**WEST SUSSEX COUNTY COUNCIL
STRATEGIC PLANNING CONSULTATION**

**SUBJECT: LU/44/14 - Approval of Reserved Matters following outline approval
LU/355/10 for phase 2, 185 units for layout, appearance scale and landscape of dwellings.
Departure from the Development Plan.**

Land South of Courtwick Park, Courtwick Lane, Littlehampton, West Sussex

The following comments are made in respects of drawing number P802/BEL/PH3&4/01.

Figure 5: Site Layout

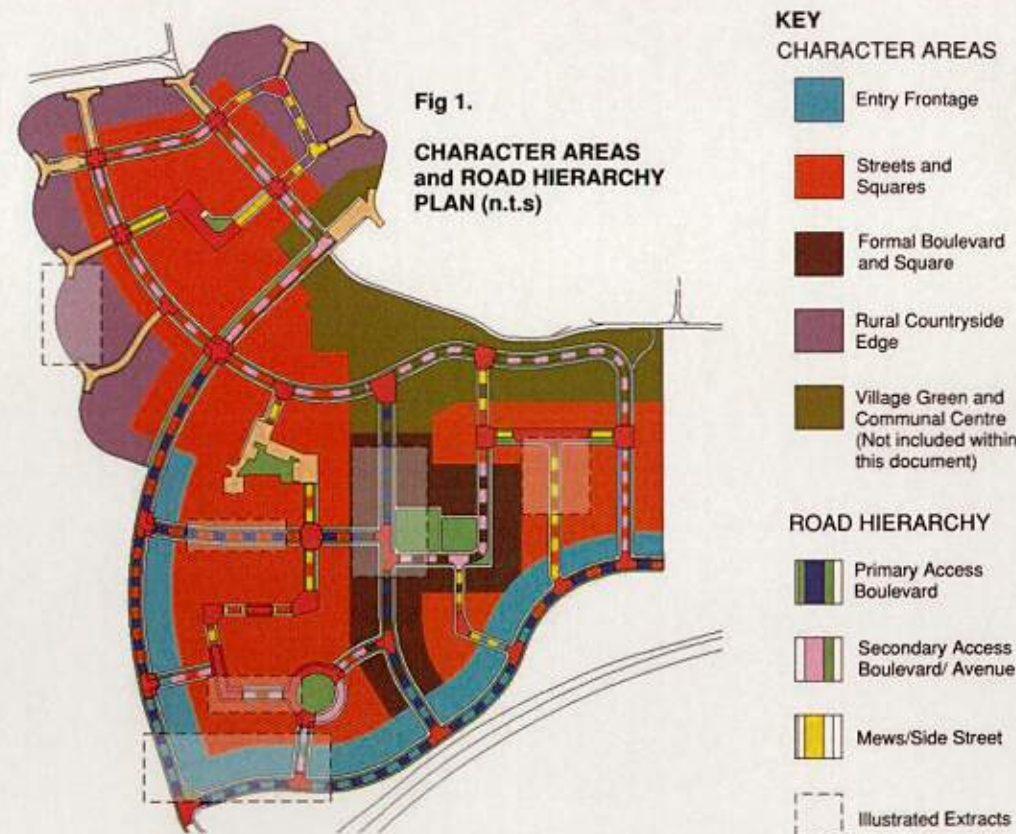
- It is unclear of the extents of the internal roads that are to be offered for adoption as public highway. It would be beneficial if the applicant could confirm their intentions.

- Carriageway widths along through routes are generally 5.5 metres wide with 2 metre footways. Parking along these routes is in defined parking bays along the carriageway edge. Initially 5.5 metre then narrowing to 4.1 metre wide shared surfaces are shown for the majority of cul-de-sacs. 1 metre service margins are shown on both sides of the shared surfaces, although there are locations where planting is shown within this. In the event that these are offered for adoption, it is likely that the Local Highway Authority would require these to be kept clear. Notwithstanding the matter of planting in service margins, these arrangements are acceptable and comply with the design principles set out within LU/355/10 as well as within Manual for Streets.

- Raised shared surface areas are proposed at all notable junctions within the site. Similar arrangements have already been accepted as part of other approved phases. The inclusion of such arrangements ensures continuity through the development for pedestrians and drivers. How these are defined, especially in terms of routes for partially sighted pedestrians and connections into standard footway construction, would need to be considered through the detailed design.

- As a specific comment, the shared surface area to the south of plot 199 is quite expansive to the point where parking could occur on the shared surface on the northbound approaches to the junction. Any parking would interfere with pedestrian routes, which themselves are lengthy across the shared surface. Whilst it is understood that this junction forms part of the bus route, it is recommended that the extents of shared surface on the northbound approach to the junction are reduced. This seems entirely feasible without affecting the operation of the junction.

- Defined parking lay-bys and planting encroach into the visibility splays at the majority, if not all, junctions. MfS advises that ideally defined parking bays should be provided outside the visibility splay. MfS recognises that in some circumstances, where speeds are low, some encroachment may be acceptable. The LHA would accept some encroachment into the visibility splays, however the applicant should define the visibility splays based on the design speed applied and identify how this parking influences visibility at the junctions.

- Planting is shown within verges alongside the highway. In the event that the roads, footways and verges are offered for adoption, the future maintenance of planting within the highway would need to be agreed as part of the Section 38 agreement. As part of the detailed design, the planting in some locations may need to be reconsidered to accommodate street lighting.

- The development will also provide access to Brook Barn Farm located to the north. It's unclear if this forms part of the current application or LU/43/11. In any case the access arrangements from and through the development should take into account the potential movements of farm traffic. The applicant should confirm if the layout has taken these into account as agricultural vehicles are more onerous than typical vehicles associated with residential units.

- Similar to the above point, whilst a private road, there is an existing through route to Brook Barn Farm via Courtwick Park Cottages. The DAS submitted with LU/355/10 indicates that this access is to be maintained. The drawing however shows no dropped kerb/bellmouth onto the proposed access road. This should be checked and the drawing amended if appropriate.

Figure 10: Parking Plan

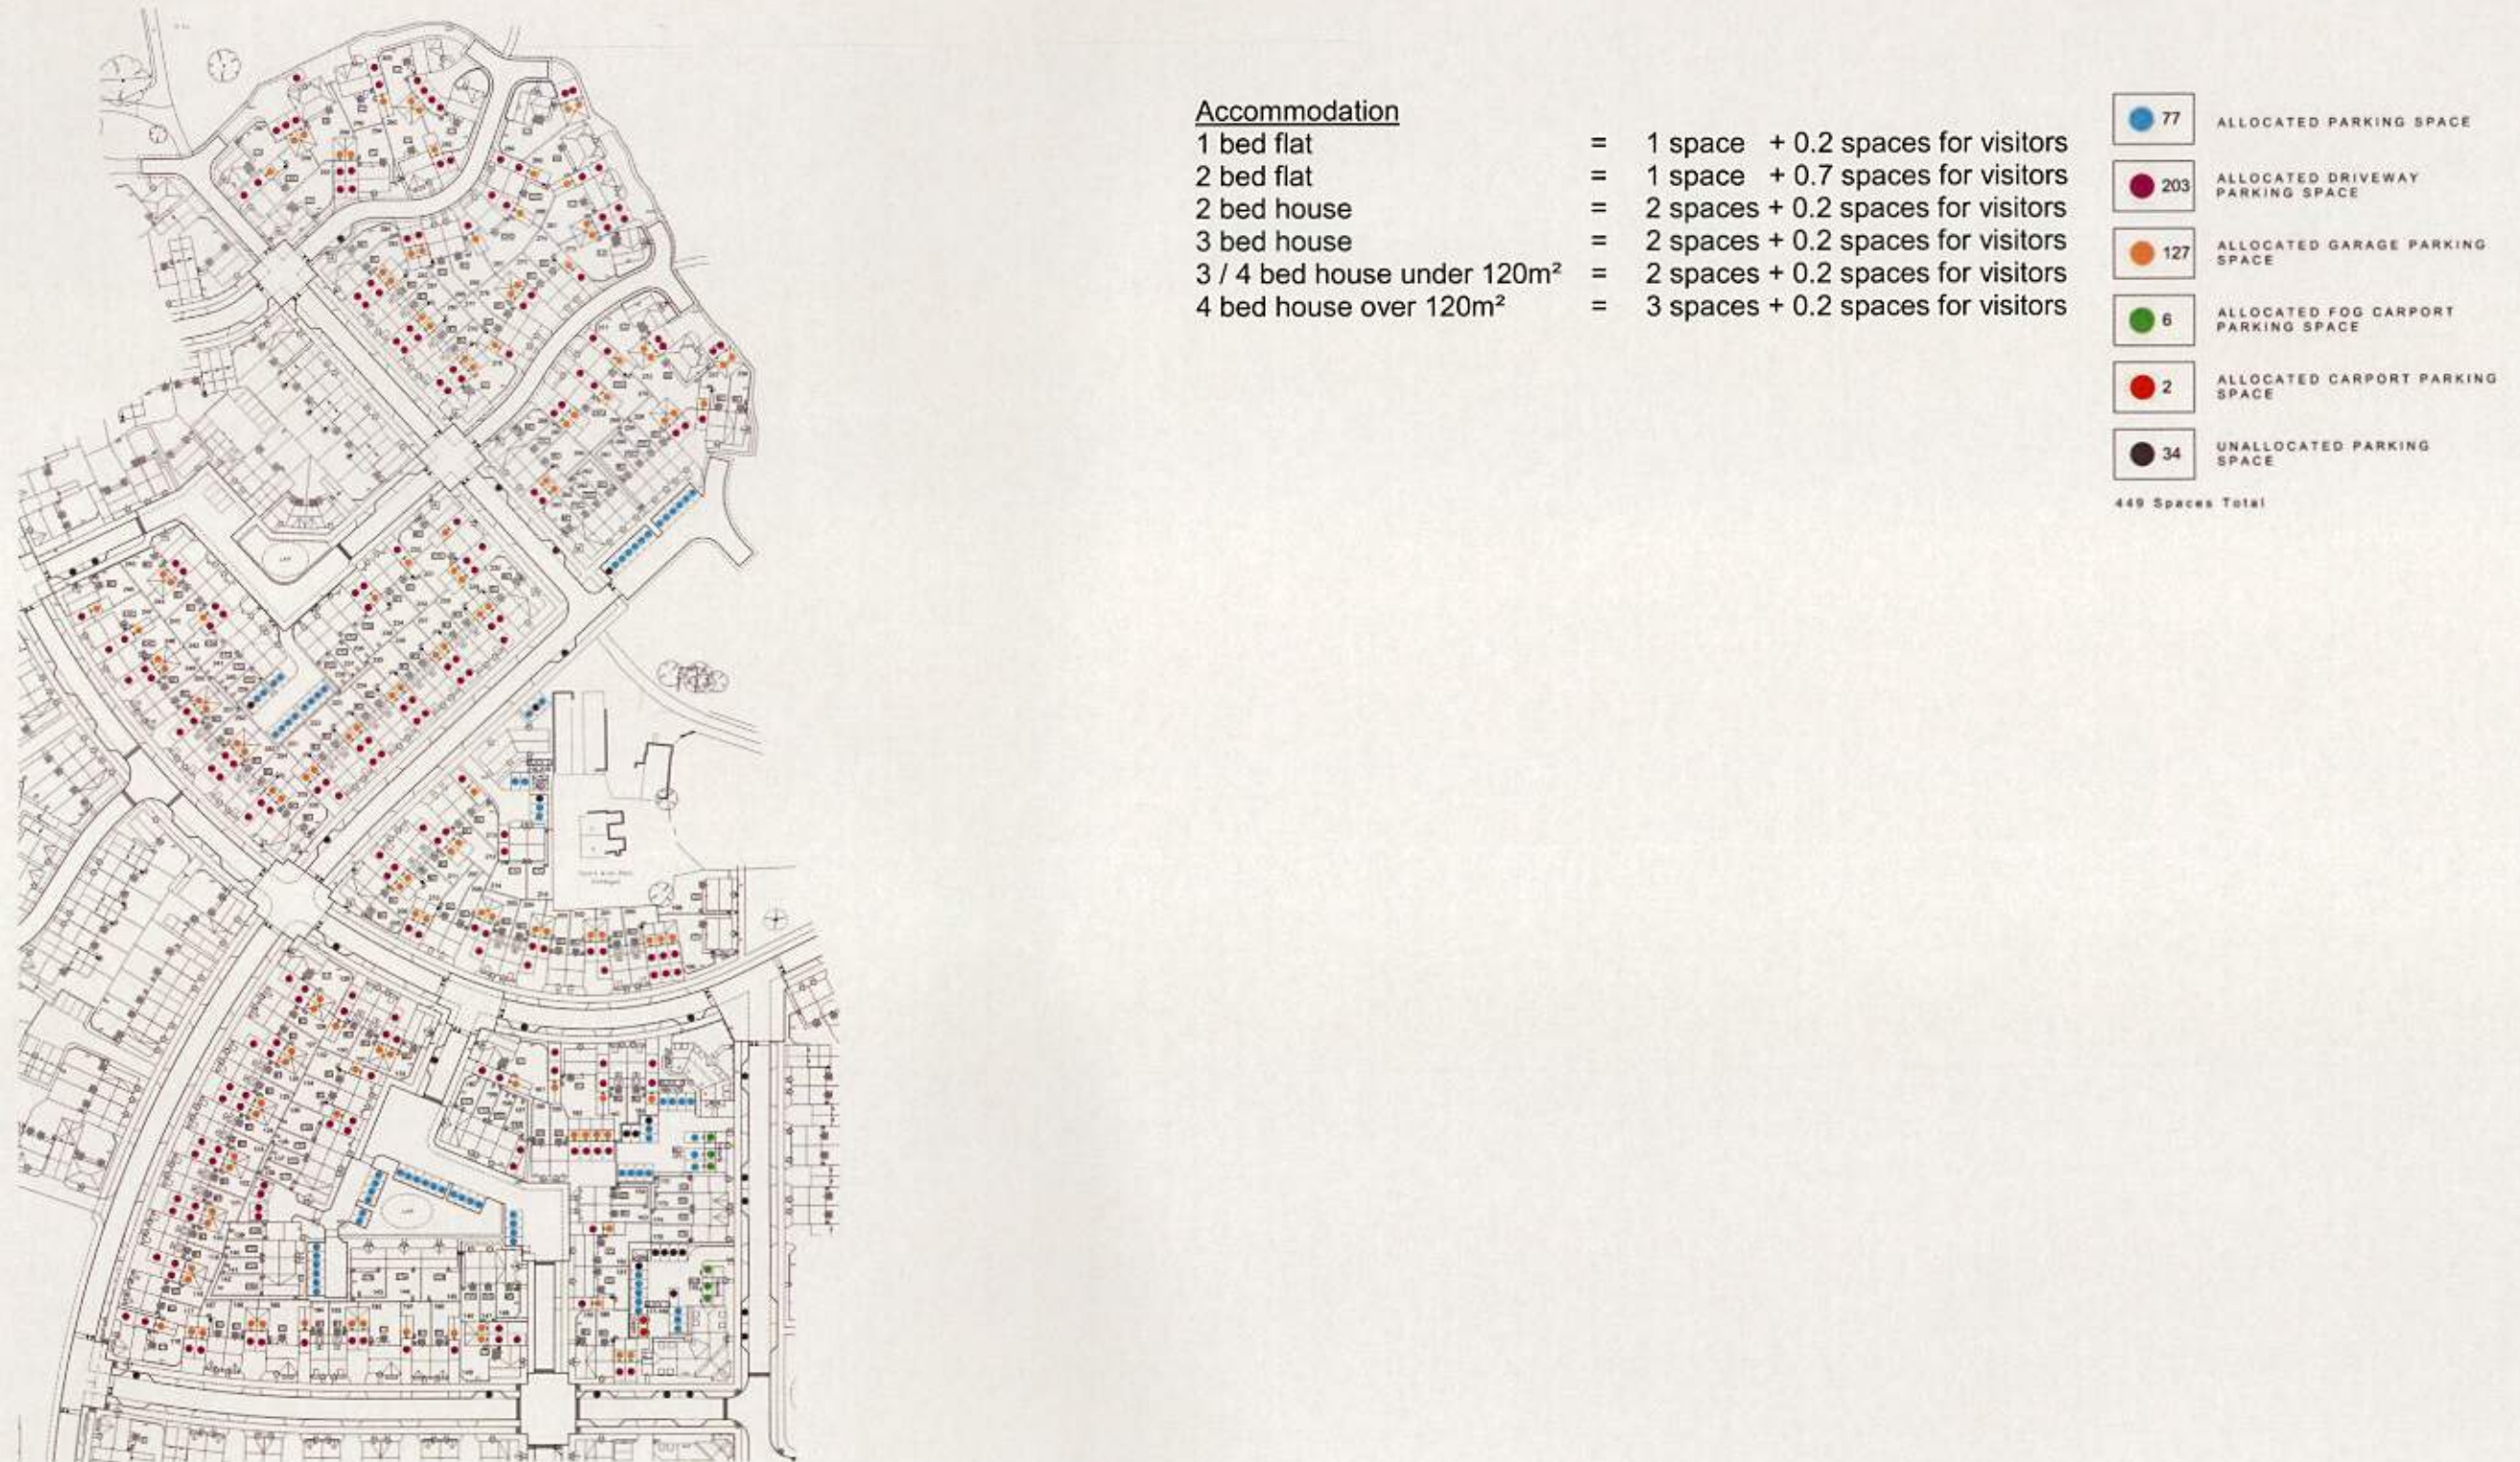
- Notwithstanding the comments about parking within the visibility splays, parking is provided across the site predominantly within on-curtilage spaces, small parking courts, as well as within defined on-street parking bays. Visitor parking spaces are distributed across the development. There are no concerns with the way in which parking is provided. It's unclear how the total parking provision has been arrived at. No references are made within the Design and Access Statement to the evidence used to forecast demands. It is strongly recommended that the applicant considers parking provision against the WSCC Parking Demand Calculator. This uses car ownership data from existing dwellings in the locality of the development to forecast potential parking demands.
